Please ask for: Sian Eggington
Email: sian.eggington@terraquest.co.uk
Telephone: 0121 2341390
Our Ref: LY/8/20/HH
Your Ref:
Date: 10th June 2020

Application for Planning Permission for Works or Extension to a Dwelling

Development: Replace existing roof, repair and repoint chimneys and insert a new dormer window on rear elevation

Location: Pauls House 254 Church Lane Lyminster BN17 7QJ

FIRST FLOOR PLAN AS EXISTING 1 : 50

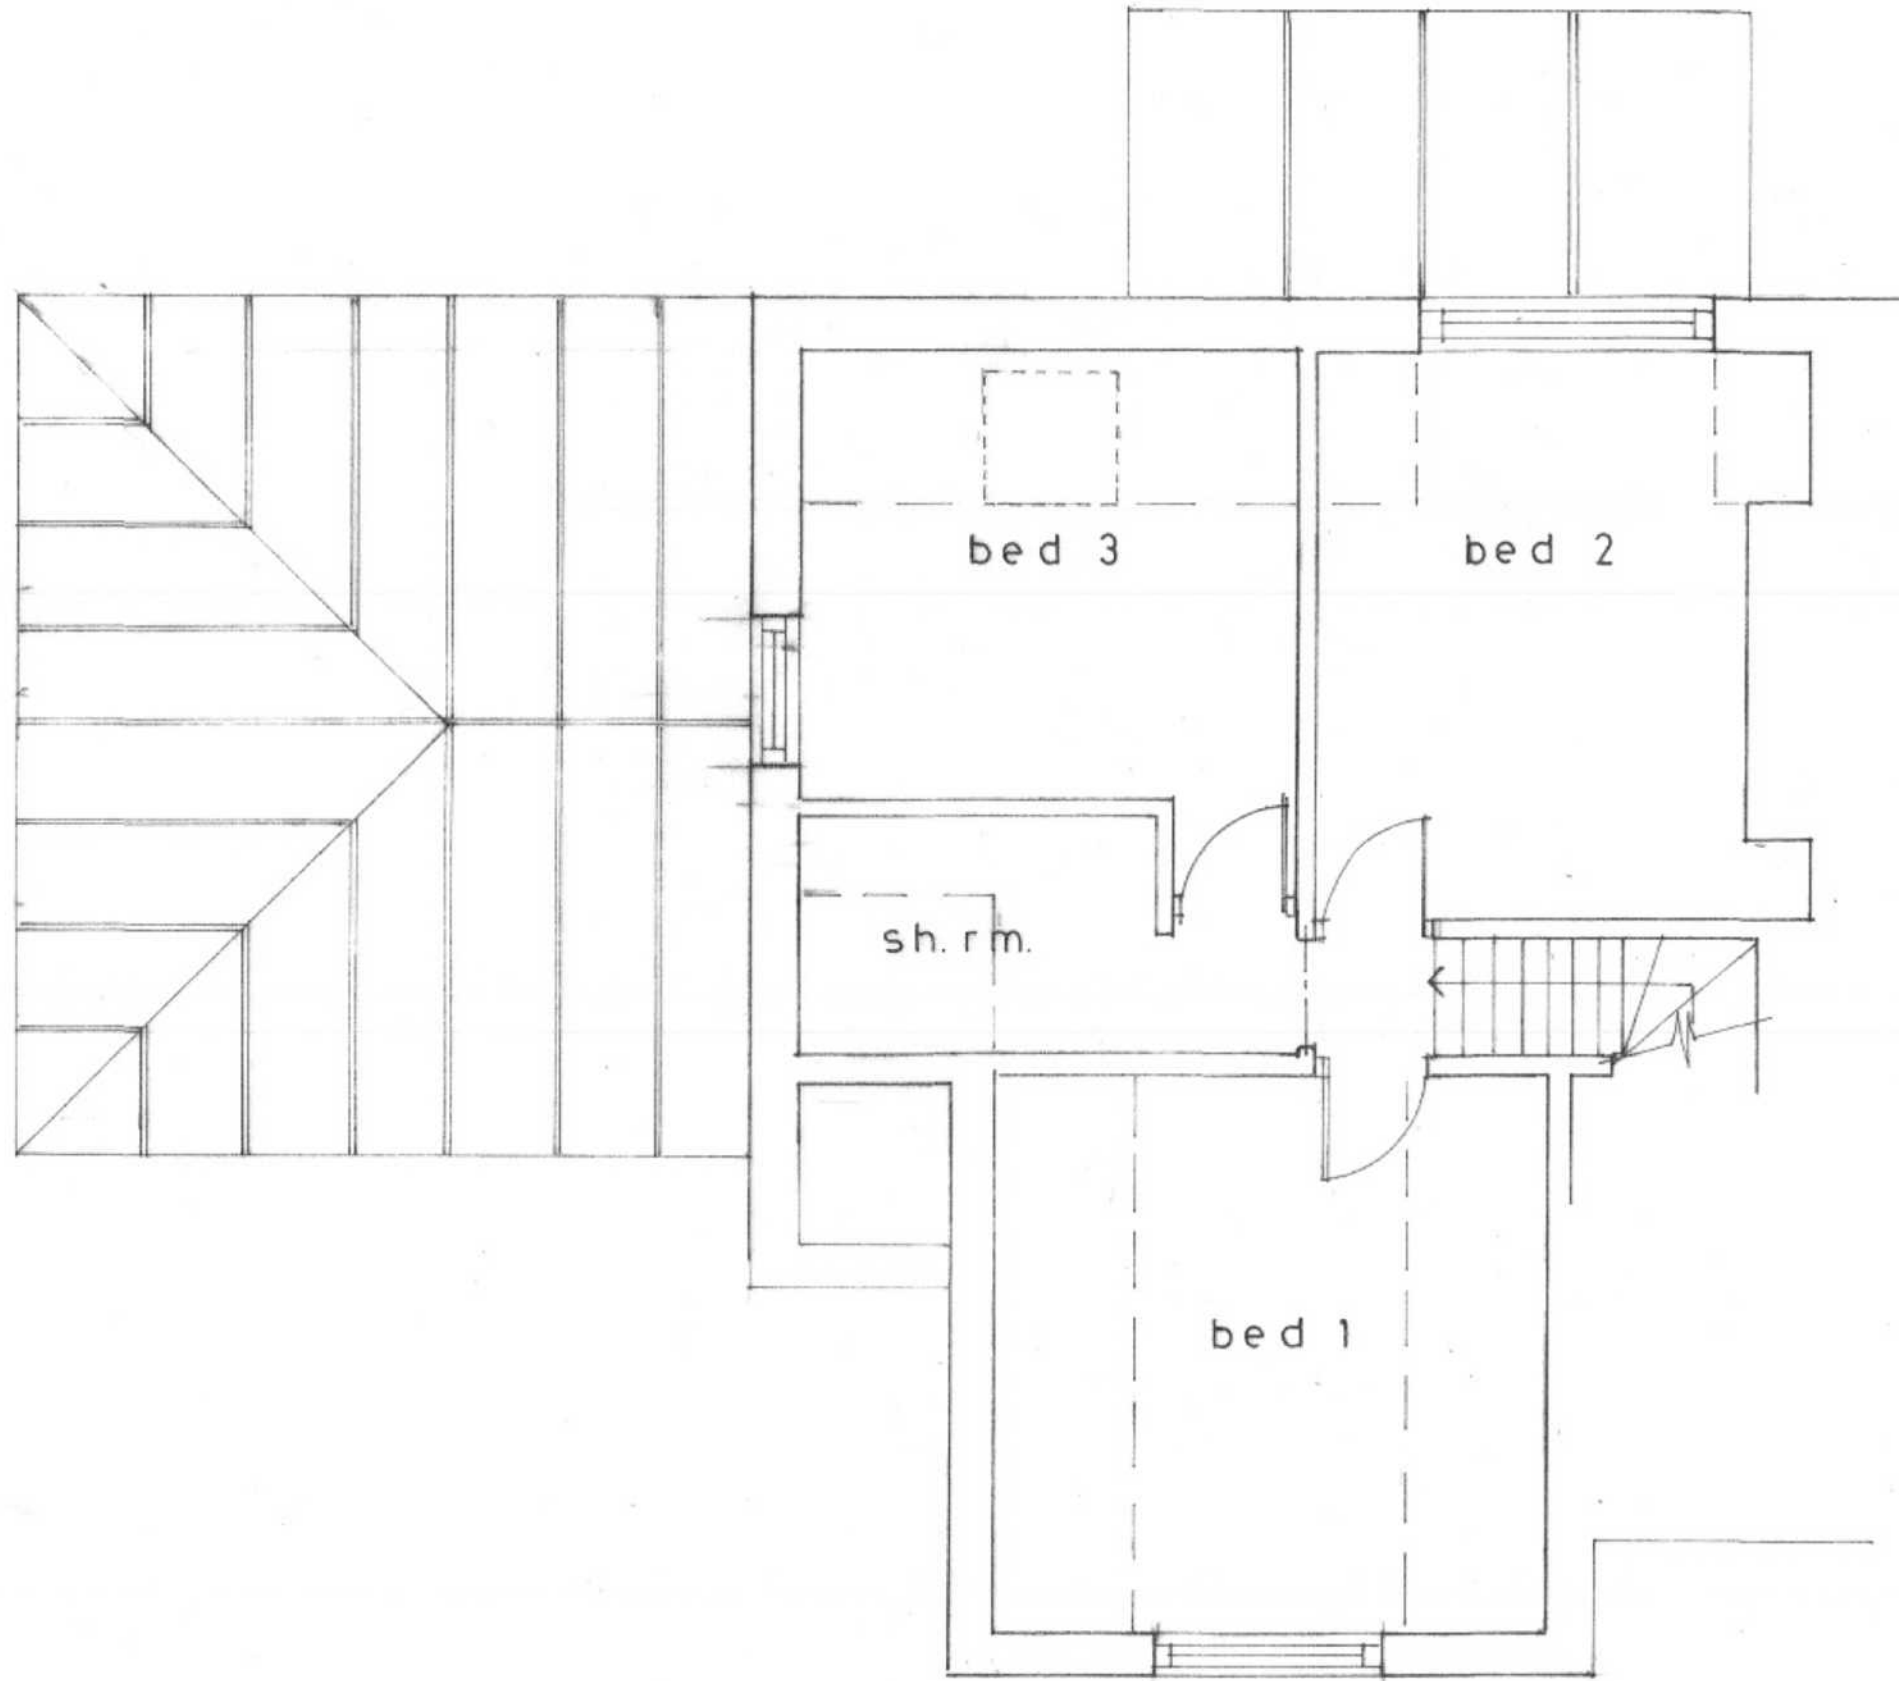
Floor Plan: You are required to provide a first floor plan show the shape of the proposed dormer on the floor plan. Please amend

ELEVATIONS AS PROPOSED 1:100

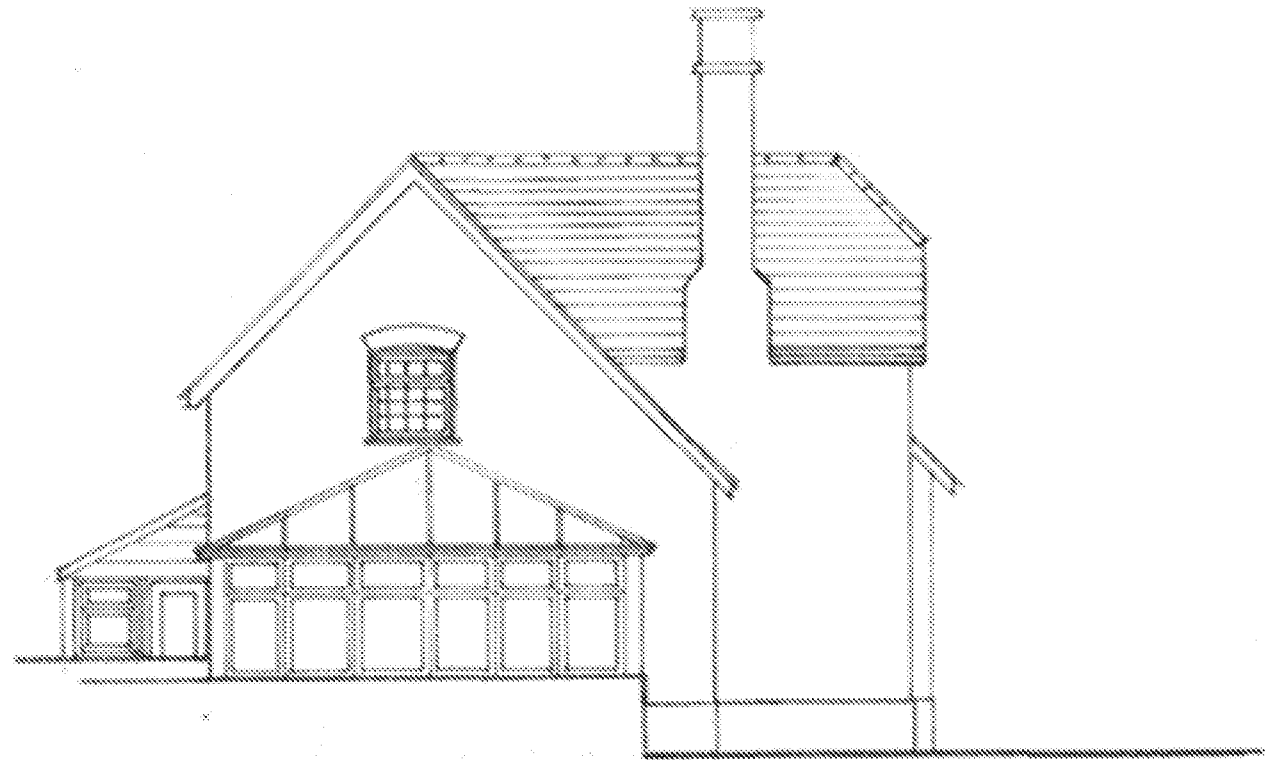
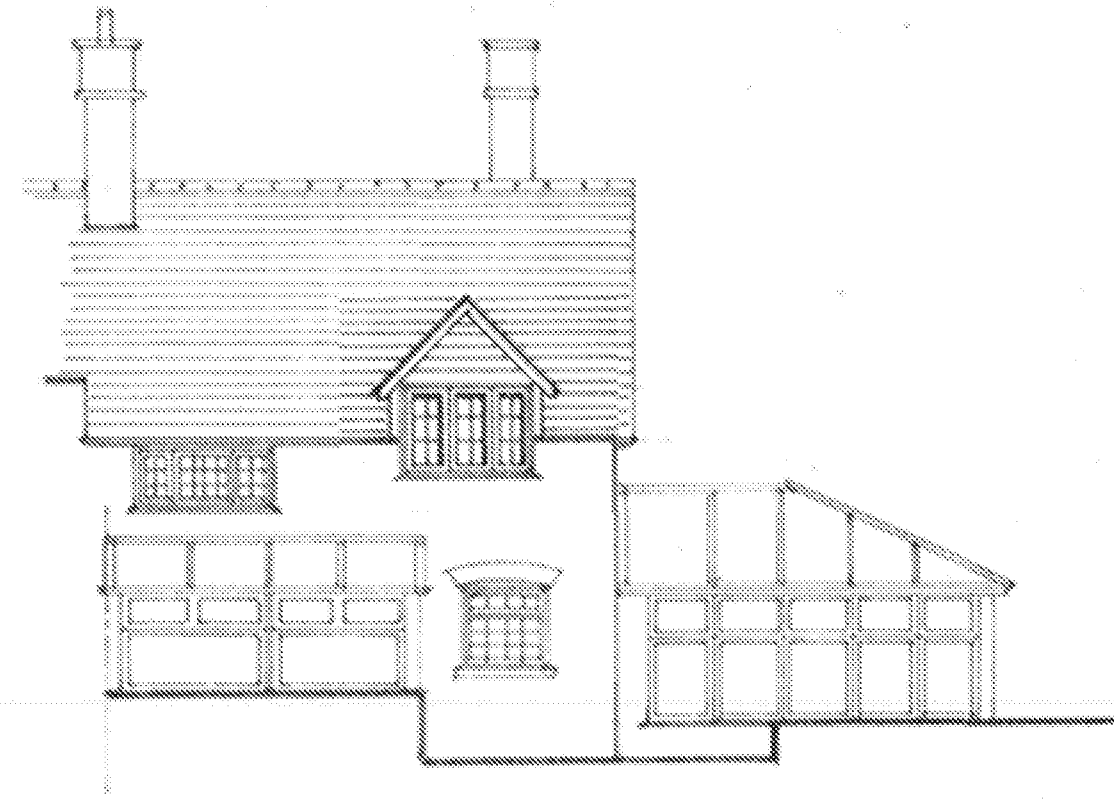
PDF: Proposed elevation needs to be a PDF document. Please amend.
